CITY OF ALBUQUERQUE

**Re: McDonald's at San Mateo and Academy
Grading and Drainage Plan
Engineer's Stamp Date 11-17-14 (E18D019C)**

Based upon the information provided in your submittal received November 25, 2014, the above referenced plan is not approved for Building Permit nor S0-19. Please address the following:

C7.0

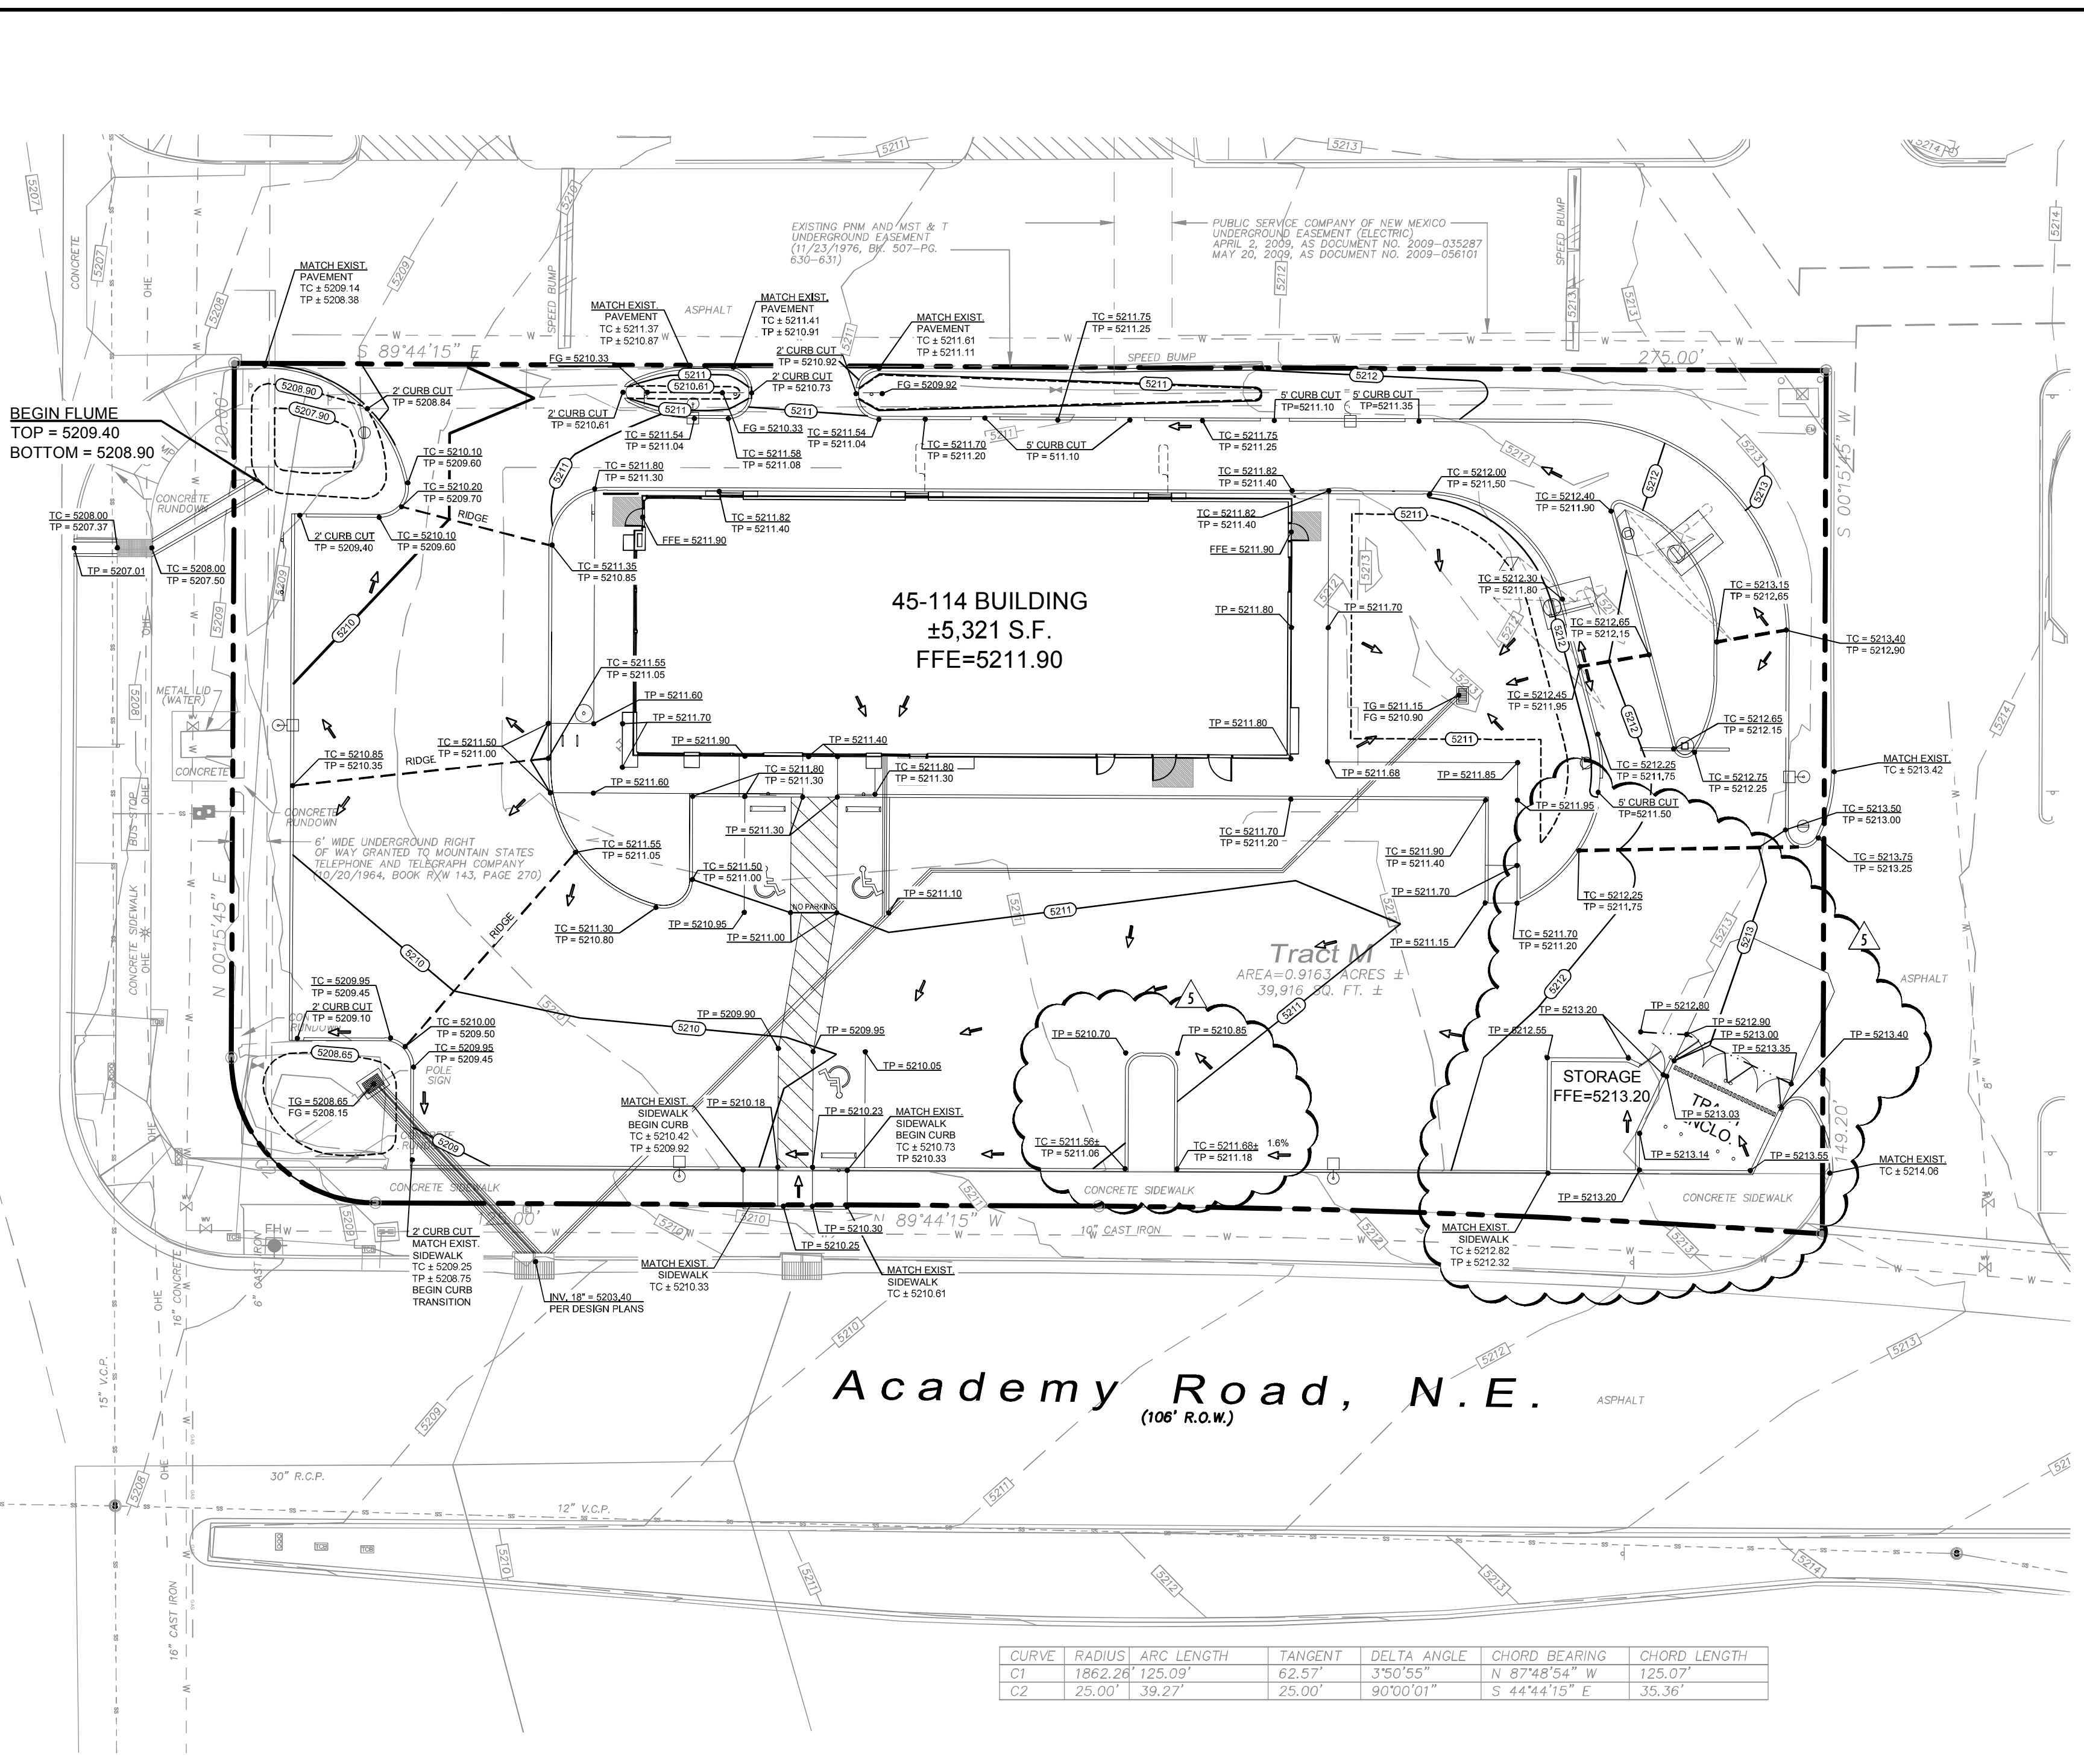
1. The existing contour elevations were turned off. Please show them.
